Energy Assessments
Department of Planning & Environment
Locked Bag 5022
PARRAMATTA NSW 2124

**SSD-10471 for Winterborne Wind Farm, Walcha
(various lots)**

5 January 2023

Winterbourne Wind Farm
 Thunderbolts Way / Jamieson Street Intersection
 Swept Path Assessment

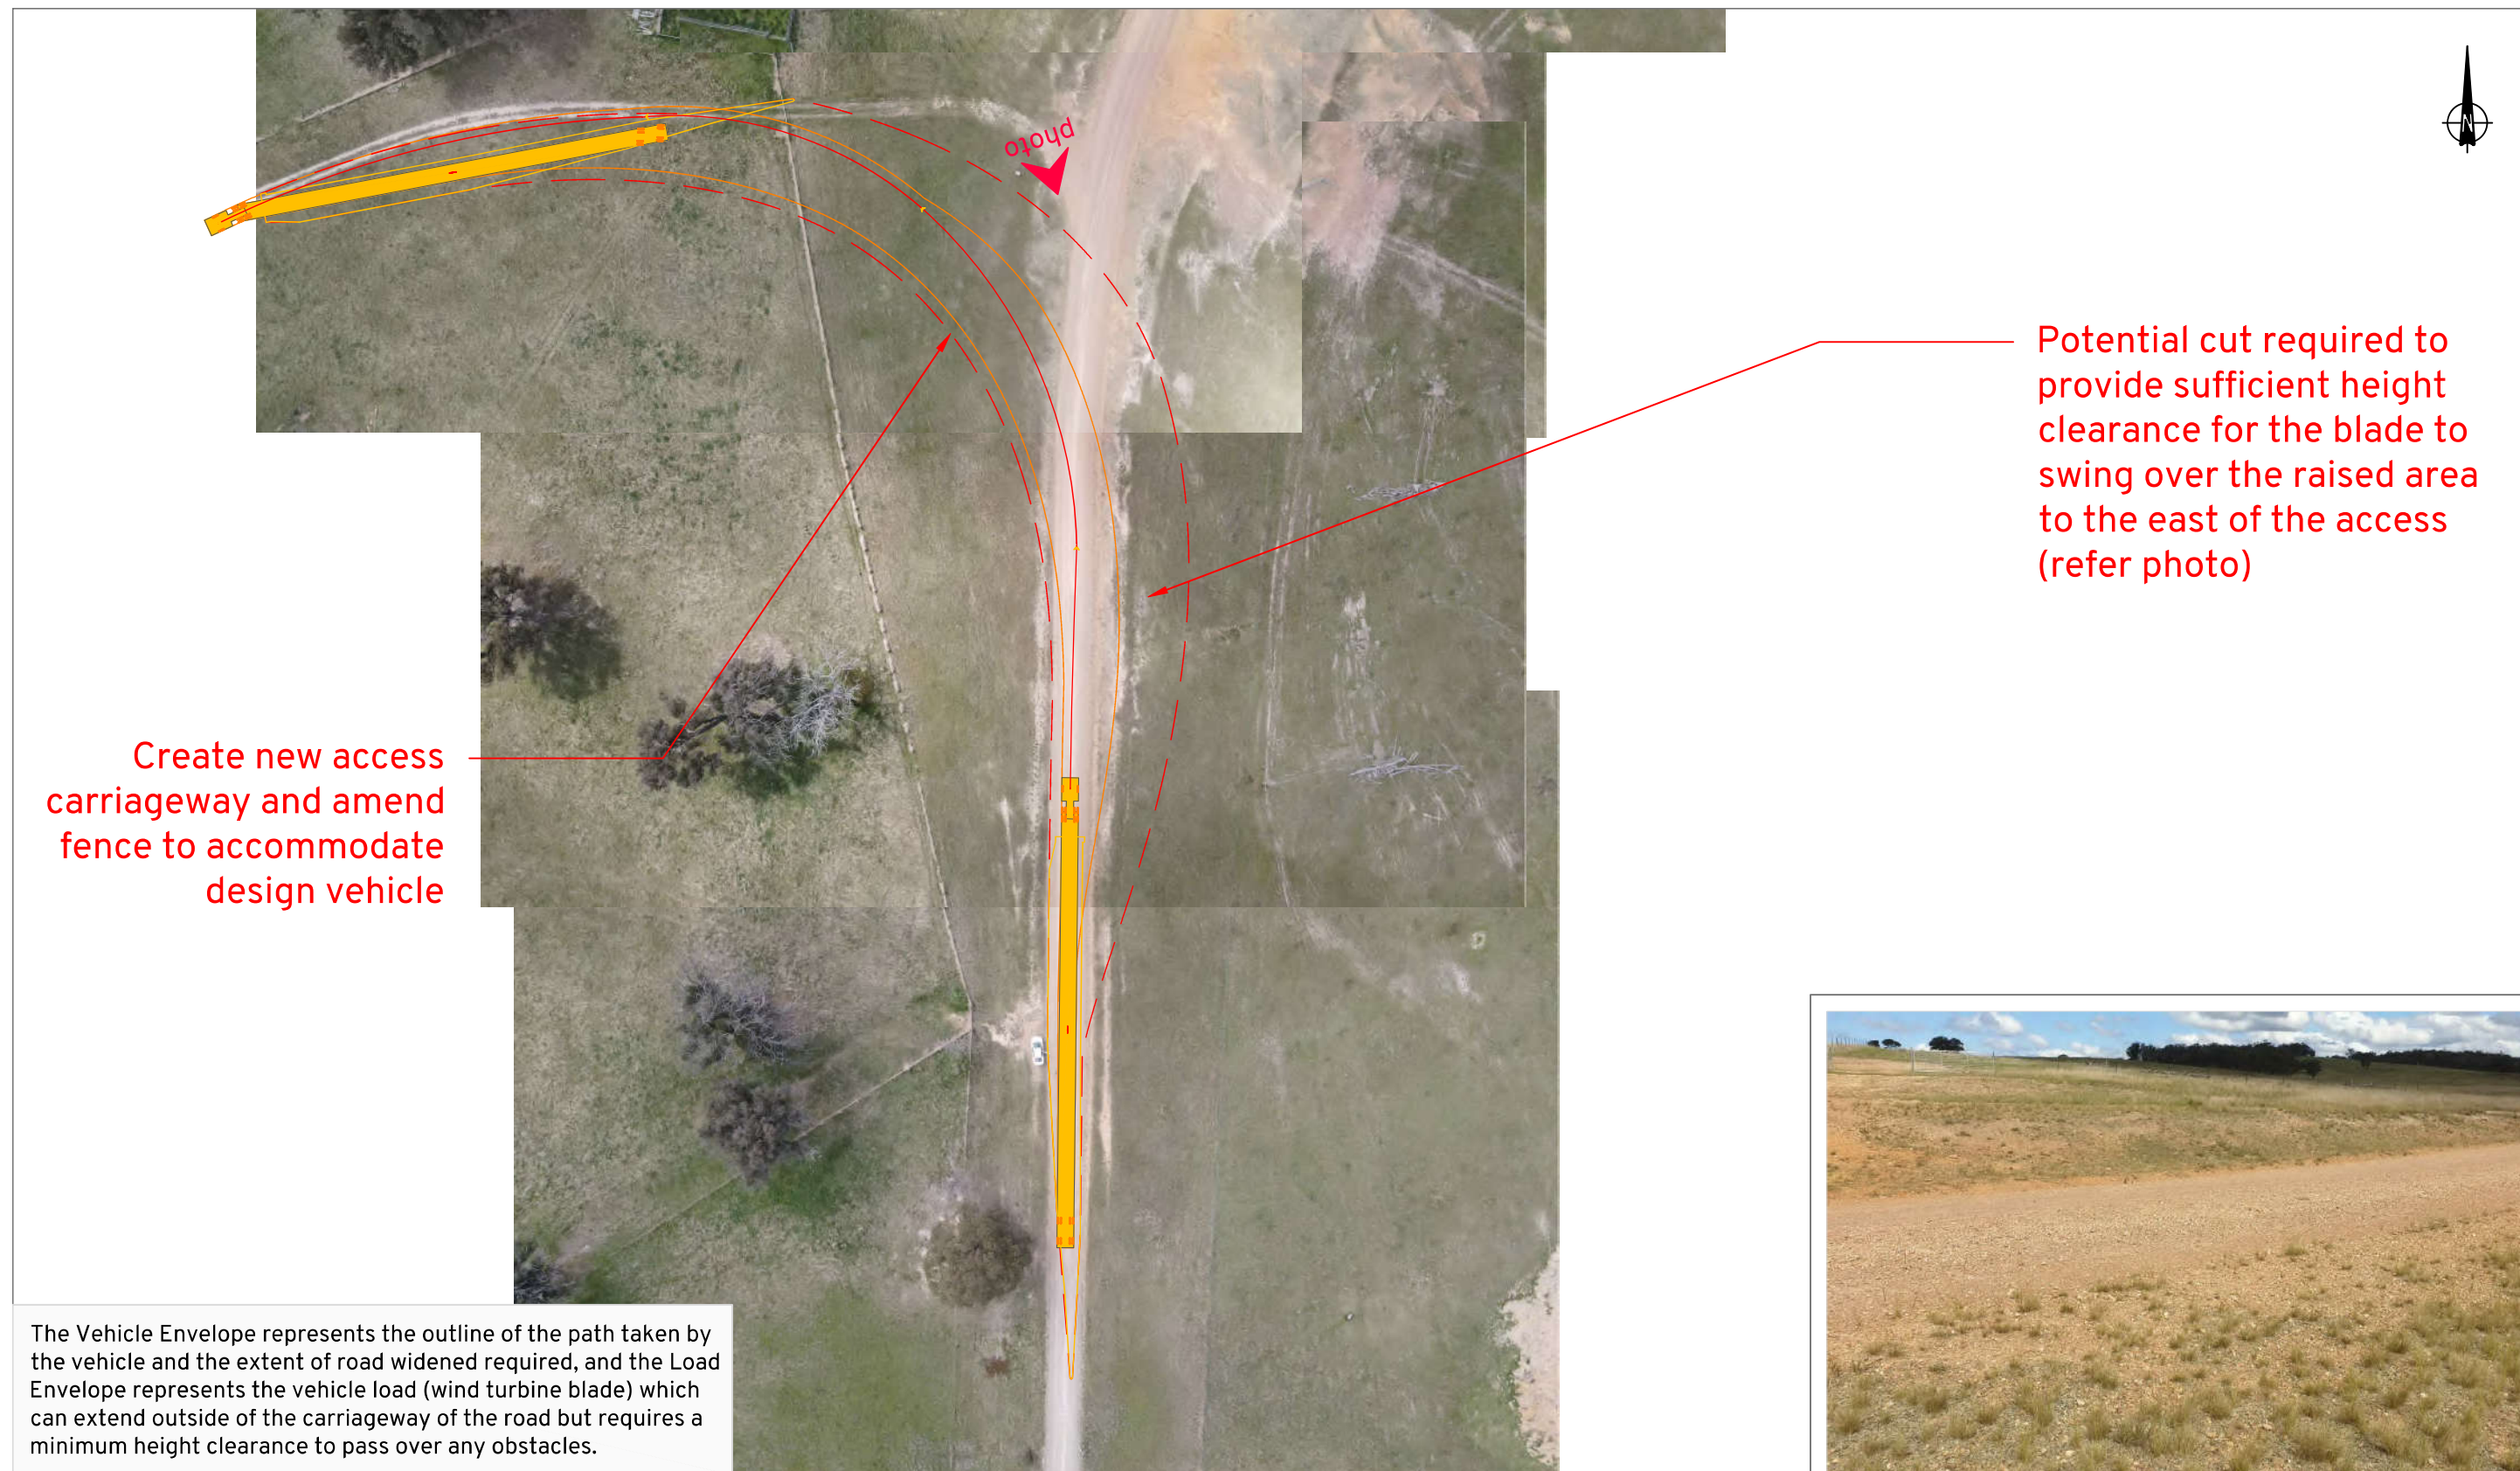
- Swept Paths demonstrated in *Appendix I* demonstrate the concurrent swept paths for a 19m Articulated Vehicle (AV) only, however, the project proposes to utilise a variety of Heavy Vehicles (HVs) including 19m Truck and Dog trailers and 26m B-Doubles. Swept paths must be updated to further demonstrate the concurrent inbound and outbound movements of both the largest design vehicle (B-Double) and the Truck and Dog (proposed to transport majority of materials to site) to identify any potential points of conflict at this intersection.
